Planning Consultation Response
From Sussex Area Ramblers Association
To Arun Planning Department

Arun DC Planning Application Y/10/22/PL

Erection of 15 No dwellings (including 4 No affordable units) with associated access, parking, landscaping, drainage and public open space (additional units to those approved under application Y/123/21/PL).

This objection is in relation to the proximity of PRow (footpath) 357 and a road junction / turning head that is specified as part of the extension to the existing development.

Drawing Title Sections through public right of way footpath 357

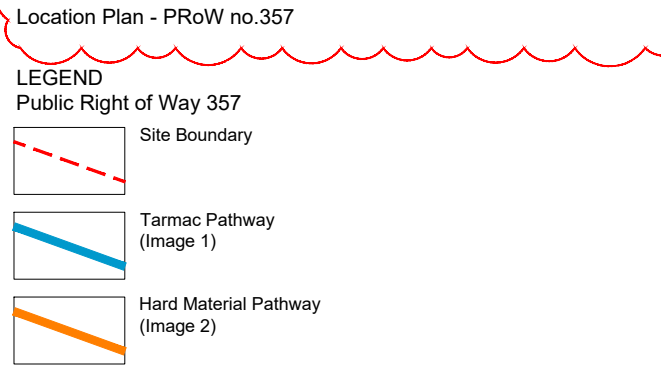
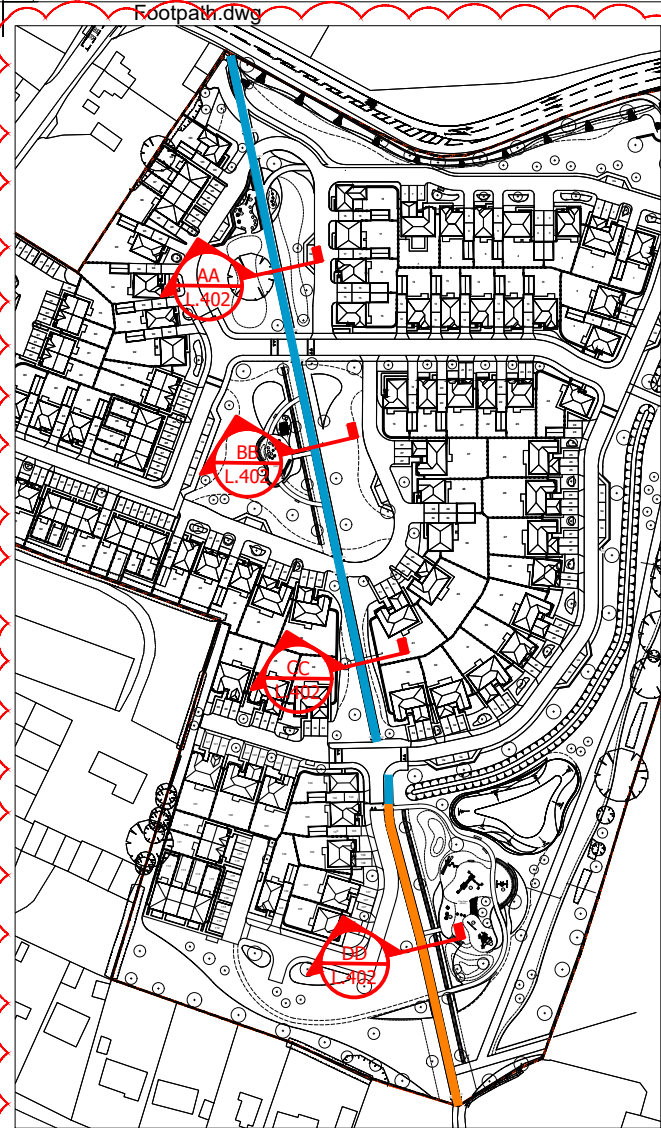
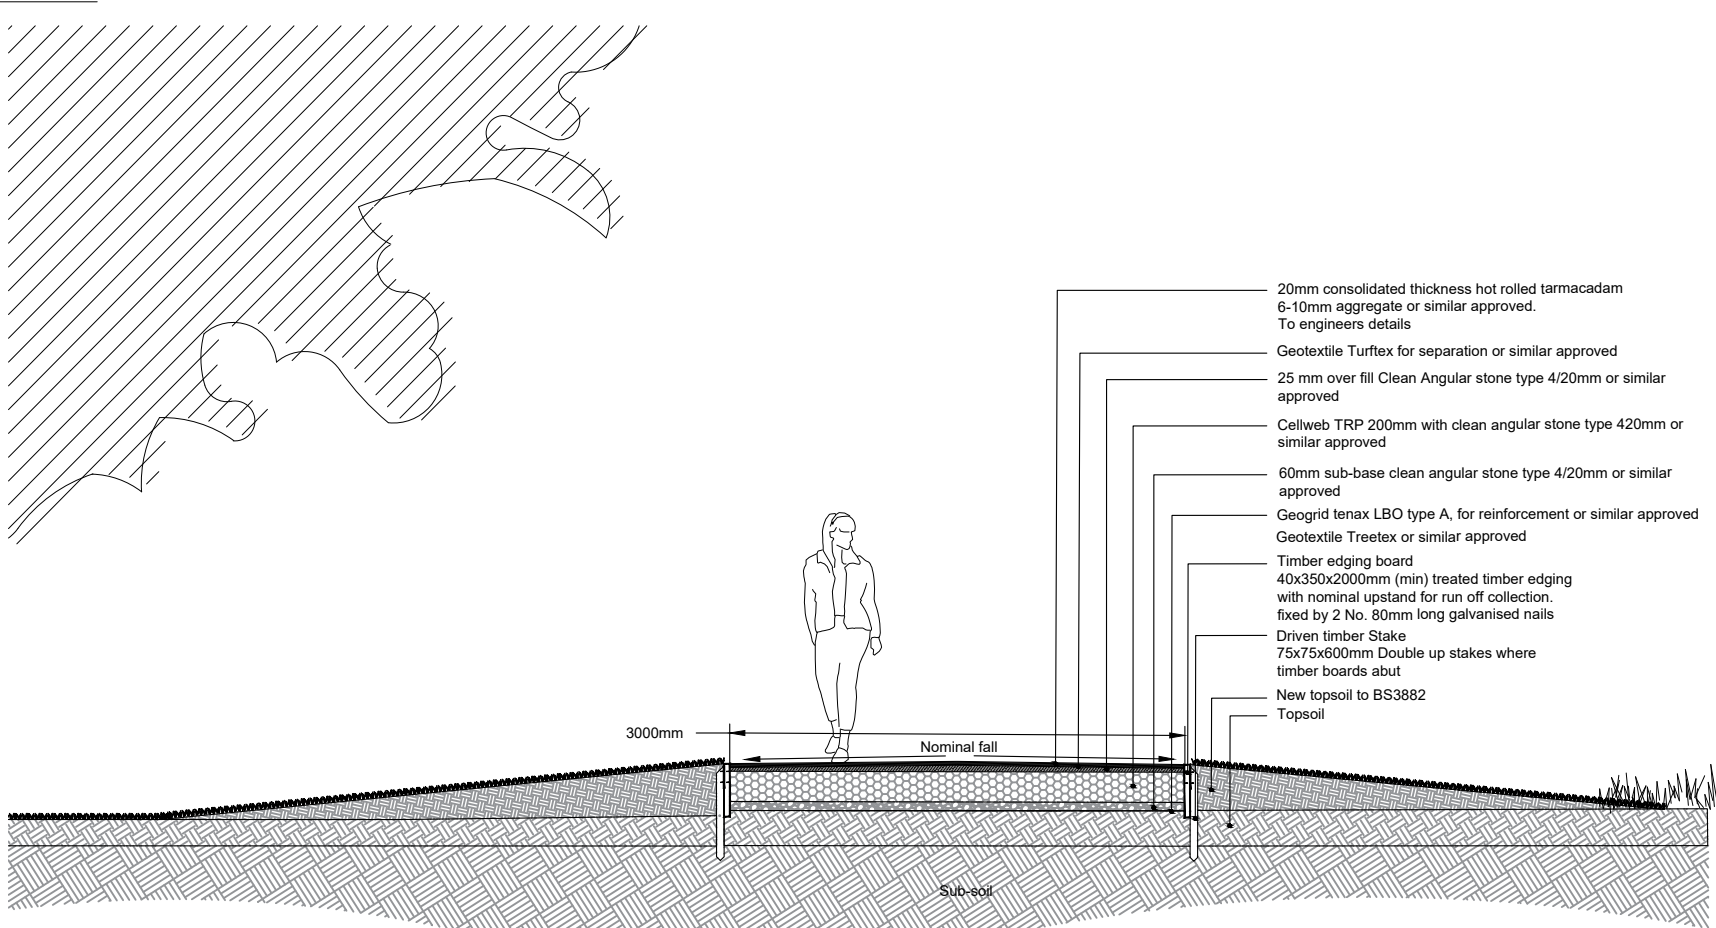
The PRow is shown crossing the junction, albeit with a possible minor deviation of the path to do so (not entirely clear from the plans). The proposed layout introduces a significant and unacceptable level of risk to PRow users.

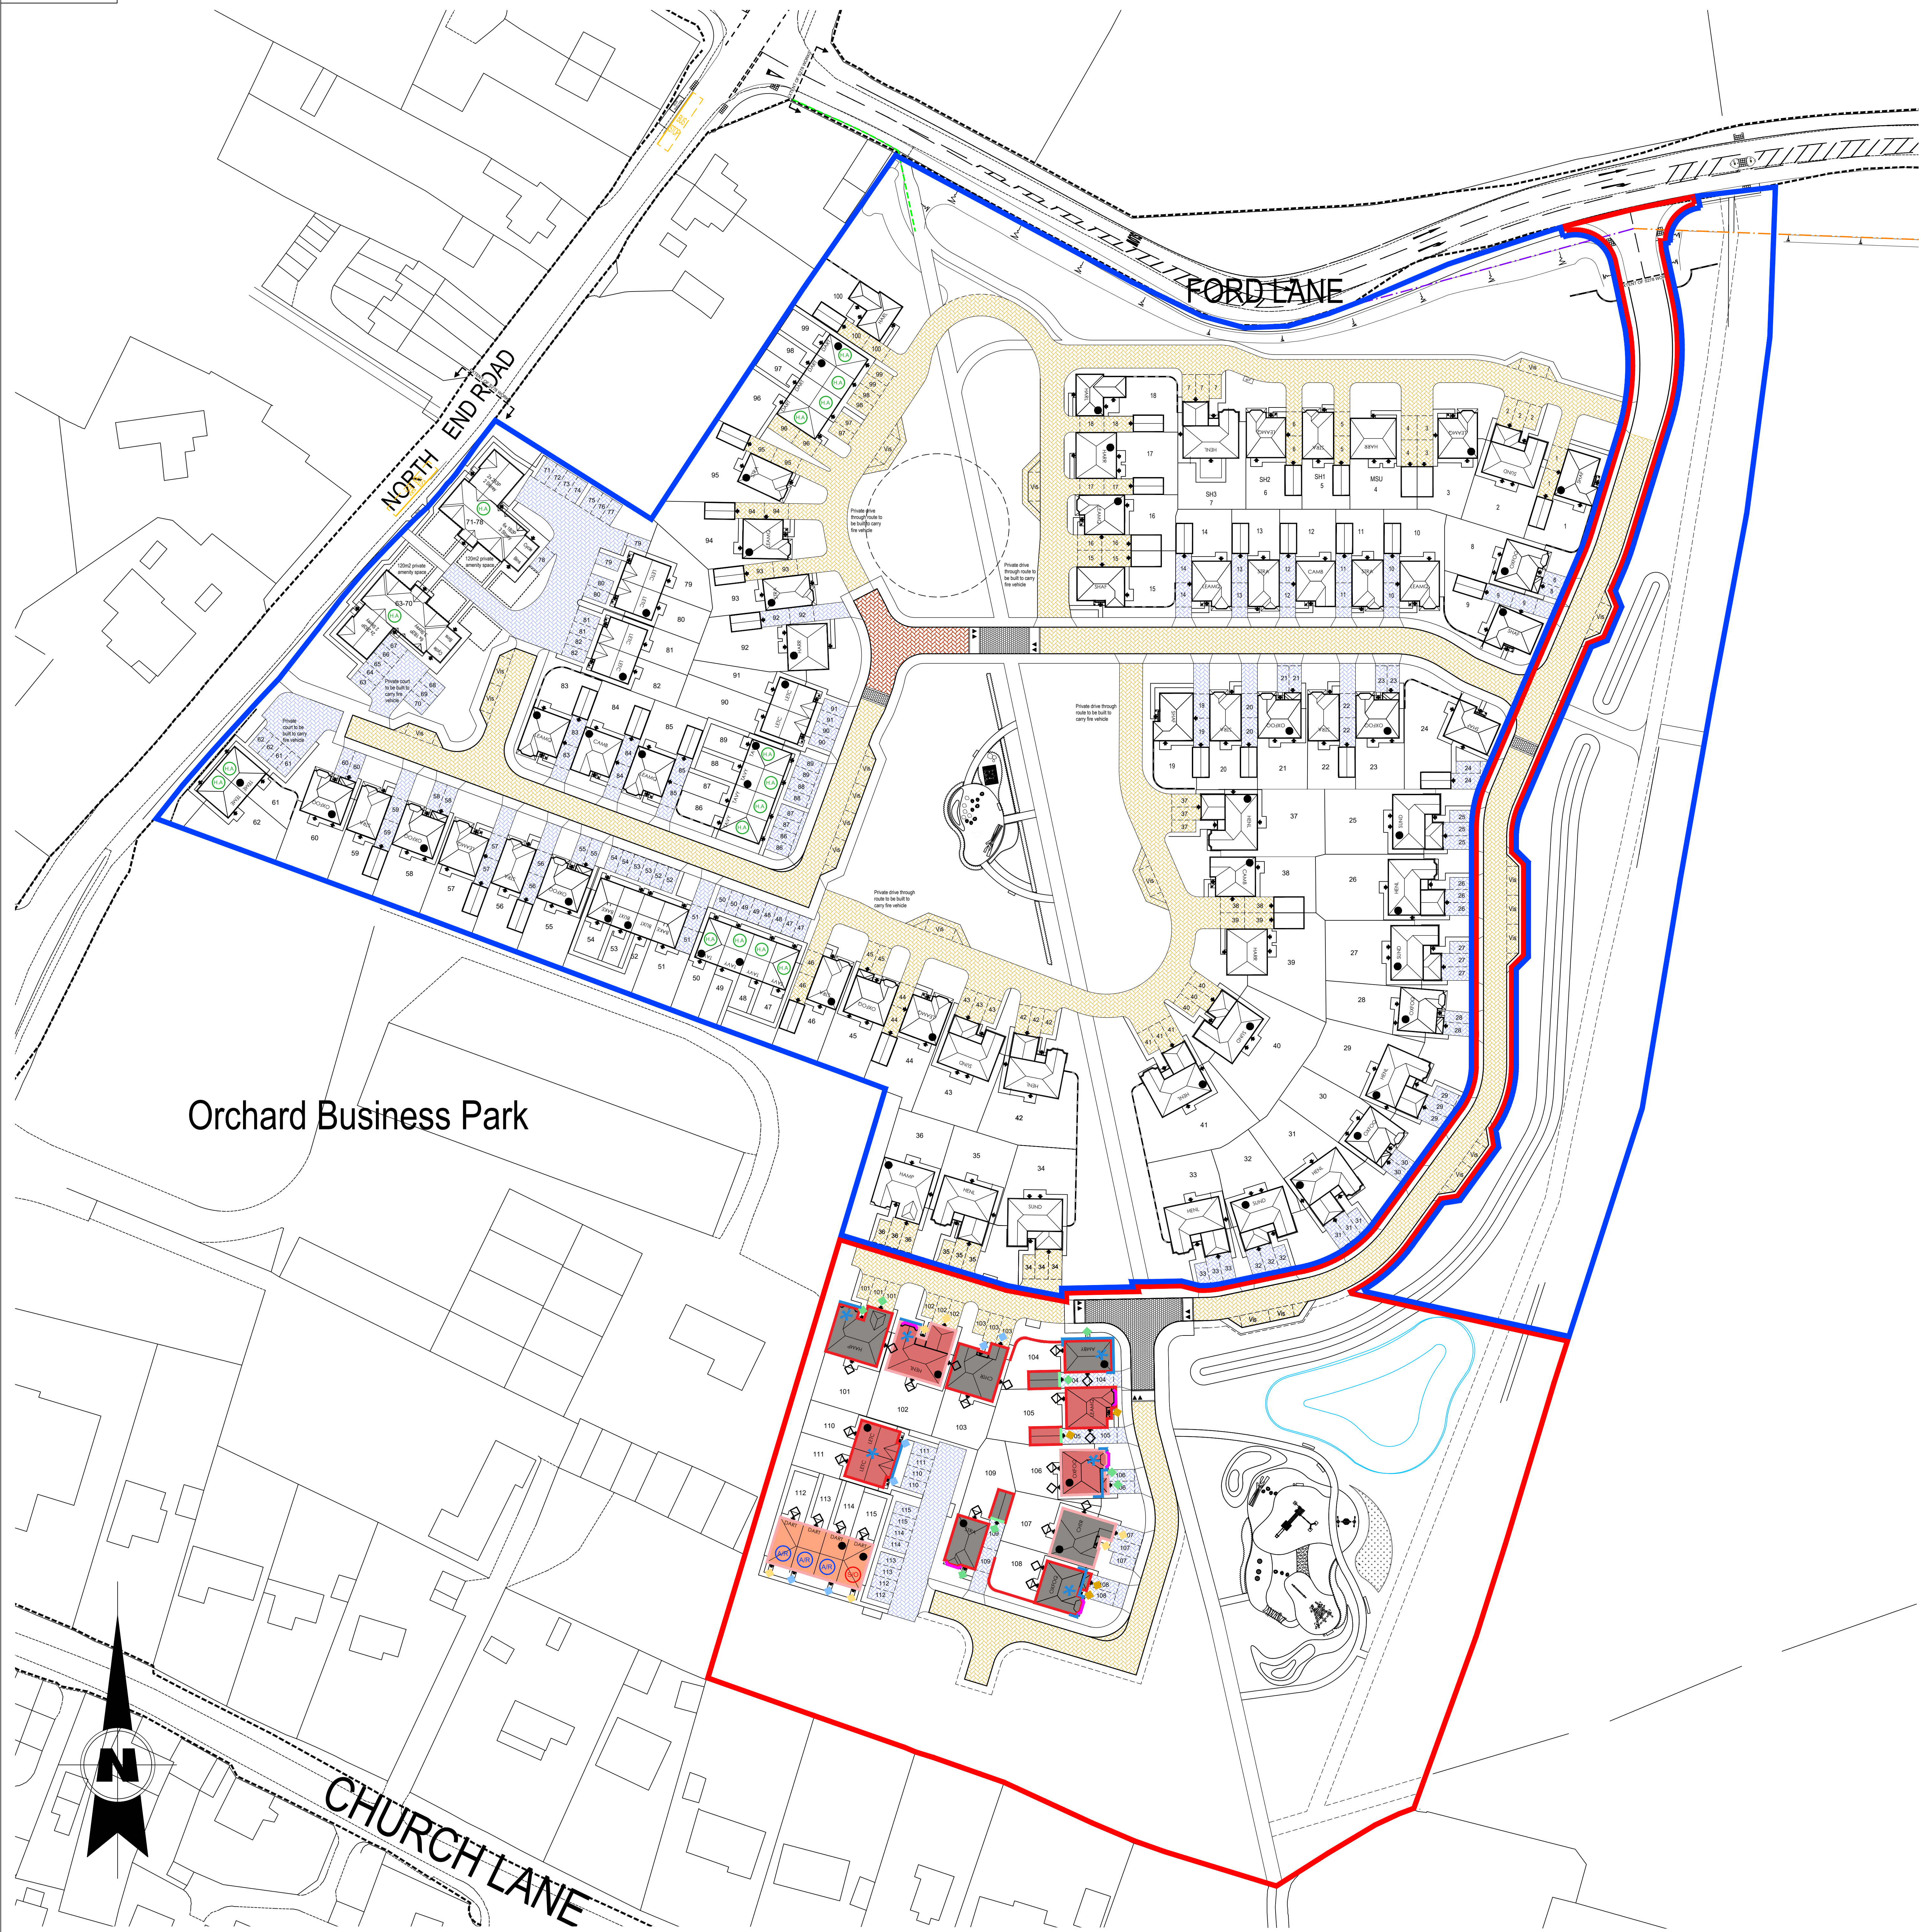
The plan also shows a children's play area to the east of the PRow and adjacent to it. This footpath will therefore form a primary access route for families and potentially unaccompanied children visiting the play area, who therefore represent a vulnerable category of path users.

Diverting the path itself is not considered sensible, given that it is common behaviour for people generally, and children in particular, to take the shortest route they can. The development layout should therefore be changed to ensure adequate separation between the junction and the PRow by moving the junction to the west in order to reduce the risk to path users, with the PRow being allowed to maintain its current line.
